From: Liz Annalls [REDACTED]
Sent: 12 January 2021 15:37
To: Planning.Responses <Planning.Responses@arun.gov.uk>
Subject: RE: Planning Consultation on: AL/2/21/DOC

Application No: AL/2/21/DOC
Site Address: Tyrone House Norton Lane Norton PO20 3NH
Description of Works: Approval of details reserved by condition imposed under ref
AL/51/20/PL relating to Condition Nos 3 - materials & finishes, 5 - Energy
Statement, 7 - car parking and 14 - external lighting

Condition 14 - External Lighting

FIGURE 2 - PROPOSED EXTERNAL LIGHTING

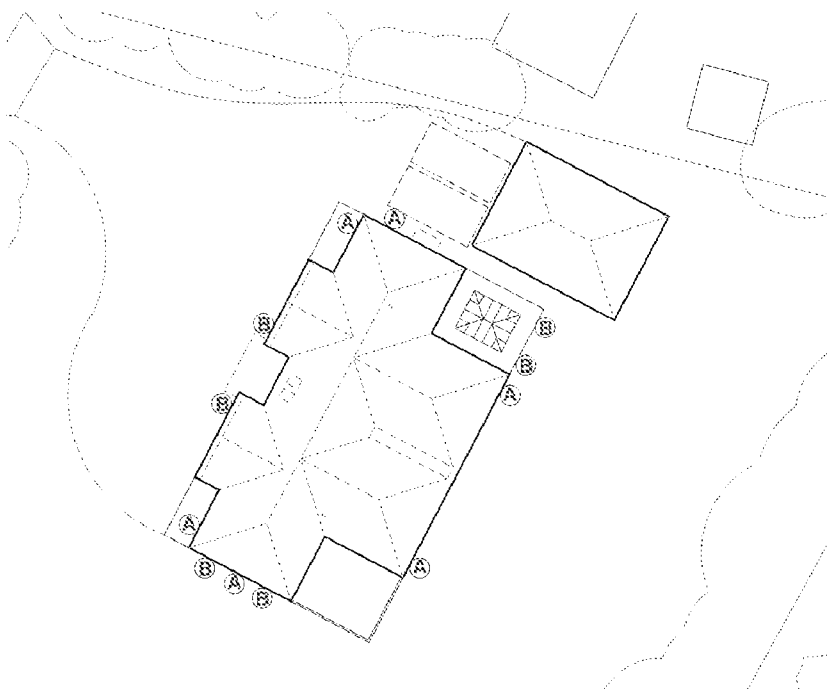
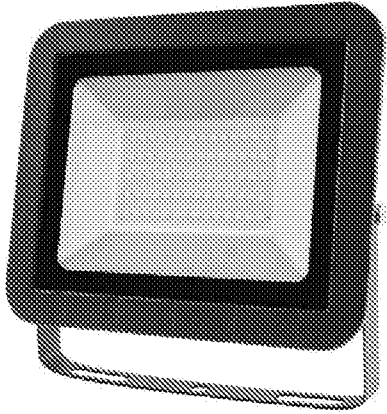
Unfortunately the proposed slim floodlight LED lights proposed for the scheme are unsuitable due to the vertical light spill they will create. We require that the lighting scheme for the site take into consideration the presence of bats in the local area and the scheme should minimise potential impacts to any bats using the trees, hedgerows and buildings by avoiding unnecessary artificial light spill through the use of directional light sources and shielding.
